Nationally Significant Infrastructure Project: EN010123 Heckington Fen Solar Park

Post Hearing Submission prepared by Lincolnshire County Council

Issue Specific Hearings (ISH) 3 & 4 & Action Points – November 2023

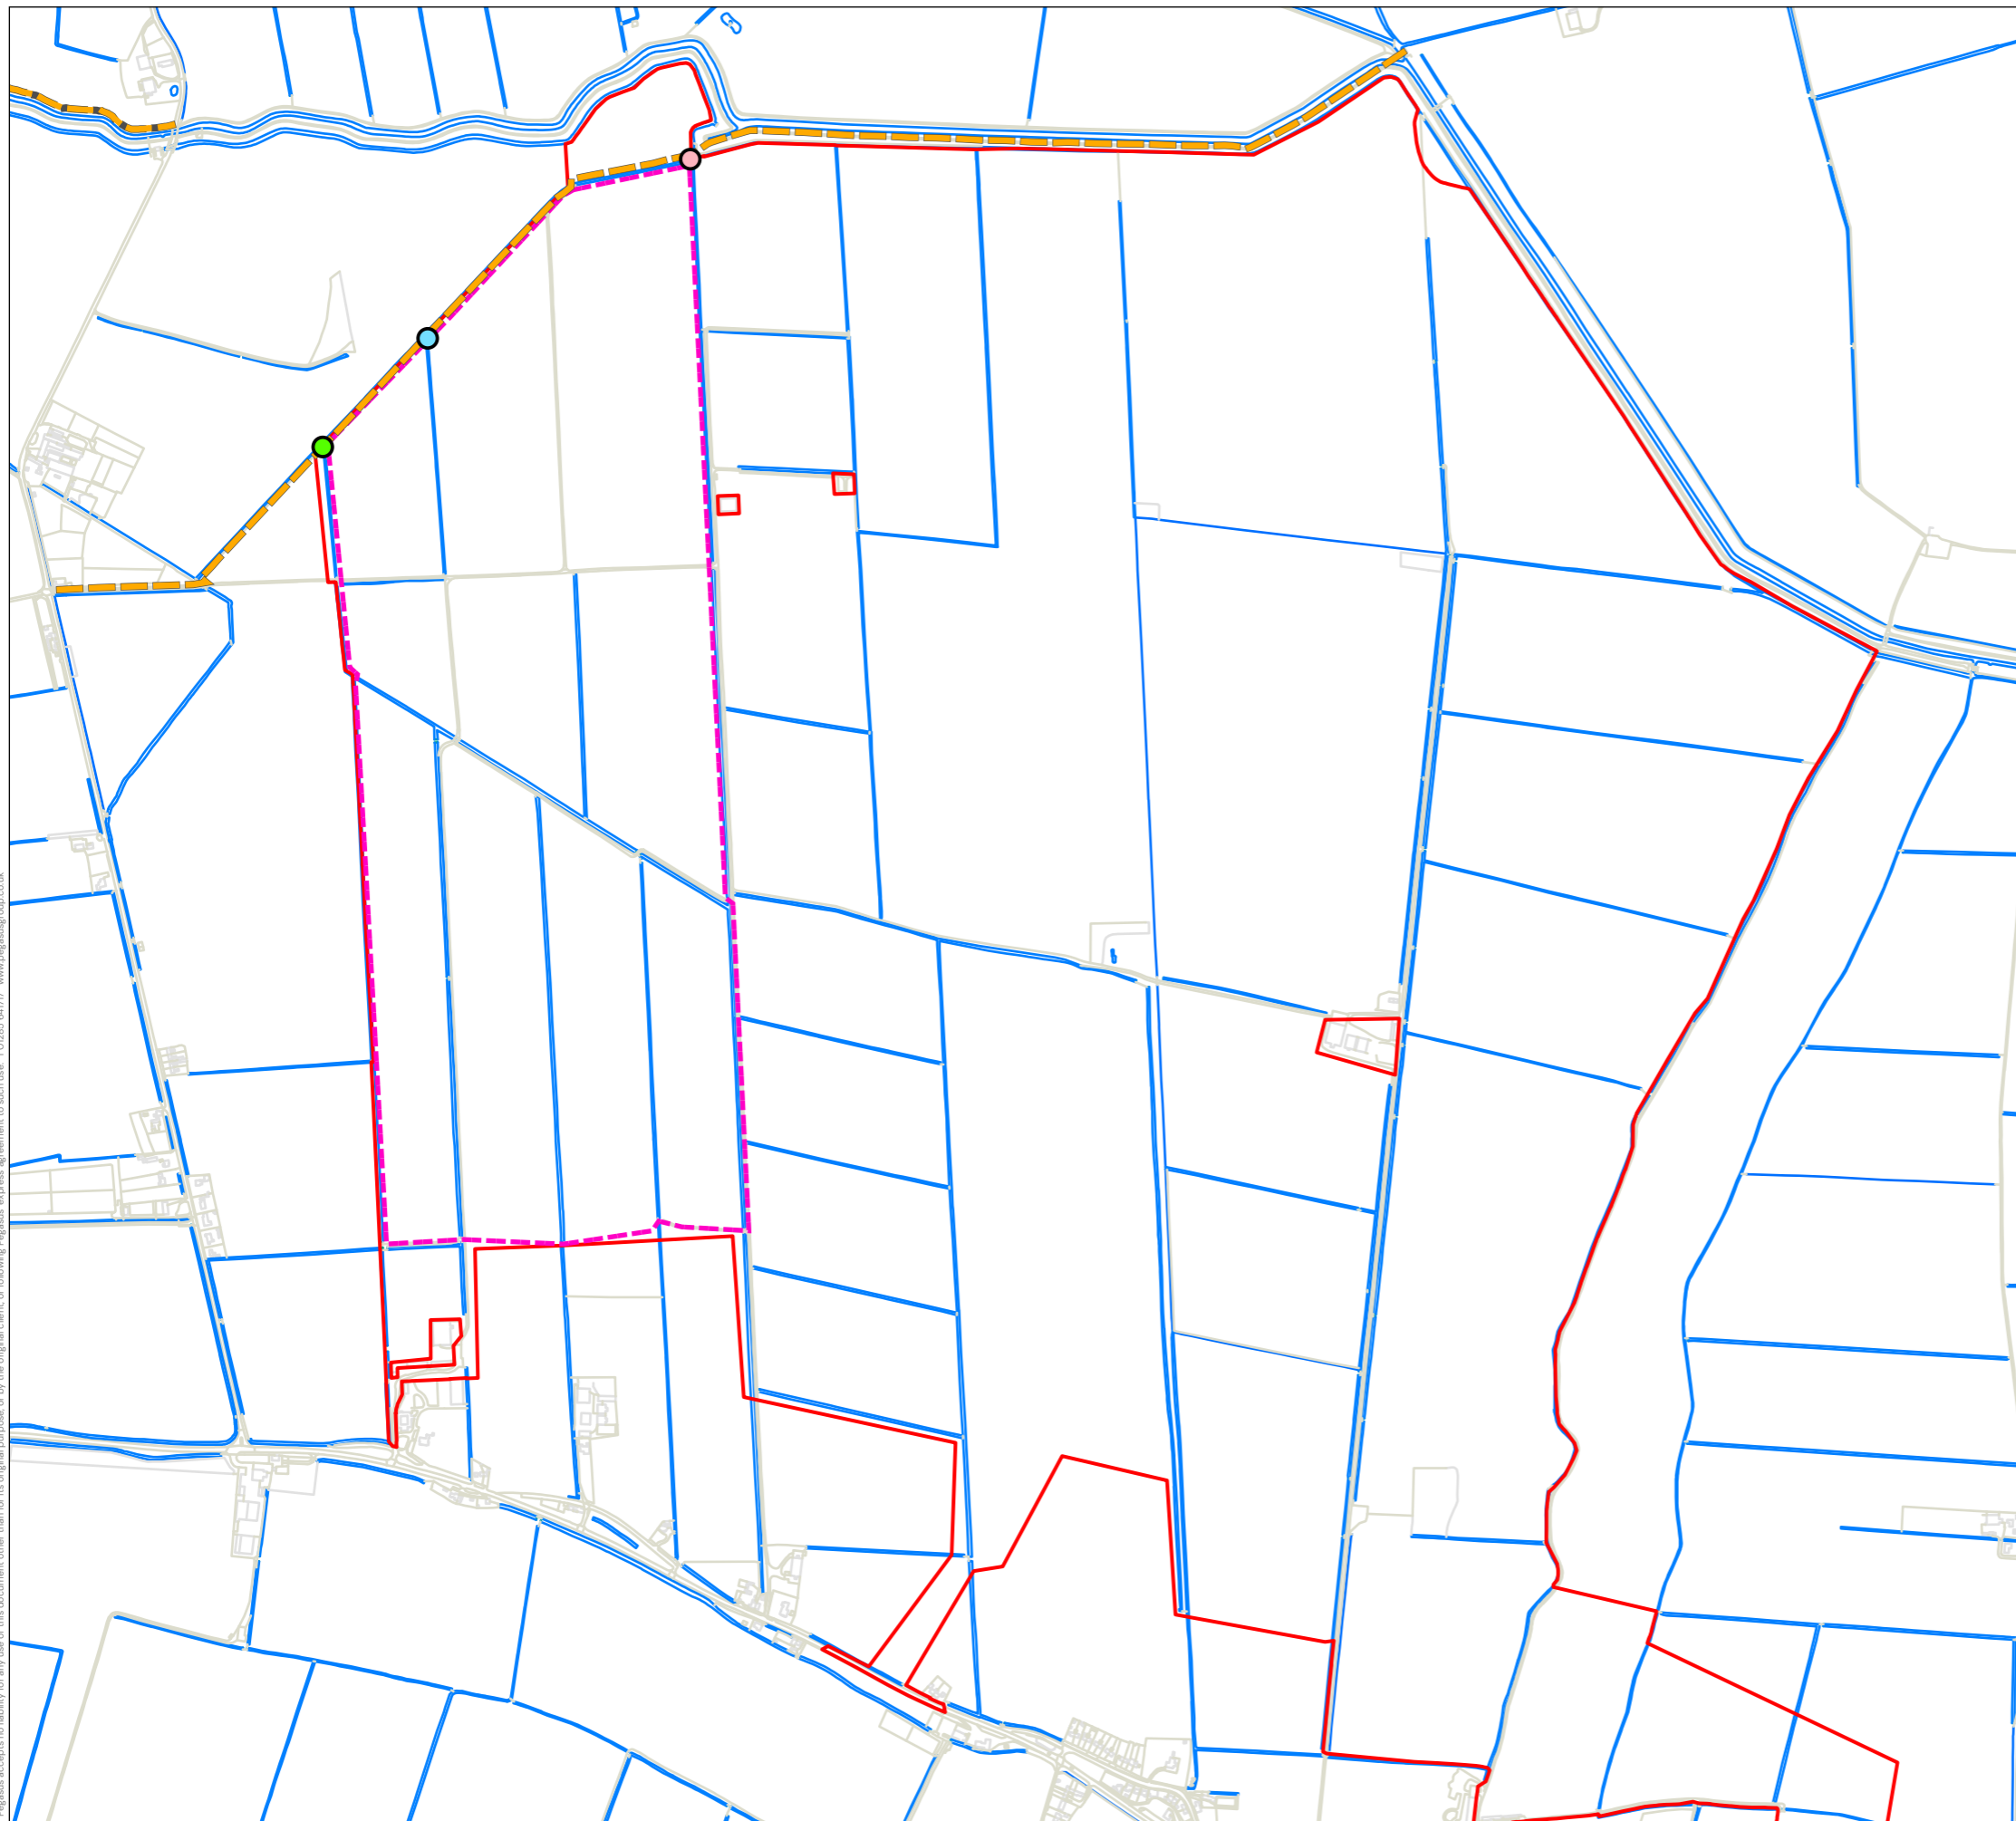
ISH3-AP5	<p>R17 (Permissive path)</p> <p>Provide written comment on the wording of R17.</p>	<p>Suggested alternative drafting for R17 is as follows:</p> <p><i>“Prior to the construction implementation laying out and provision of the permissive path, the undertaker must submit details of the permissive path details to.....”</i></p>
ISH3-AP8	<p>Schedule 13 Protective Provisions</p> <p>Consideration of additional Protective Provisions for the Lincolnshire Fire and Rescue Service</p>	<p>Post hearing discussions continued between the parties. It is understood that the Applicant is agreeable to the principle and purpose of the draft provisions but discussions are on-going as to whether this would be best dealt with as a protective provision or as a separate agreement. Discussions will continue with a view to confirm at a later date and this will be reflected in a Statement of Common Ground.</p>
ISH3-AP13	<p>Provide a response to the Applicant’s summaries as above</p>	<p>As requested LCC will provide a response by DL4.</p>
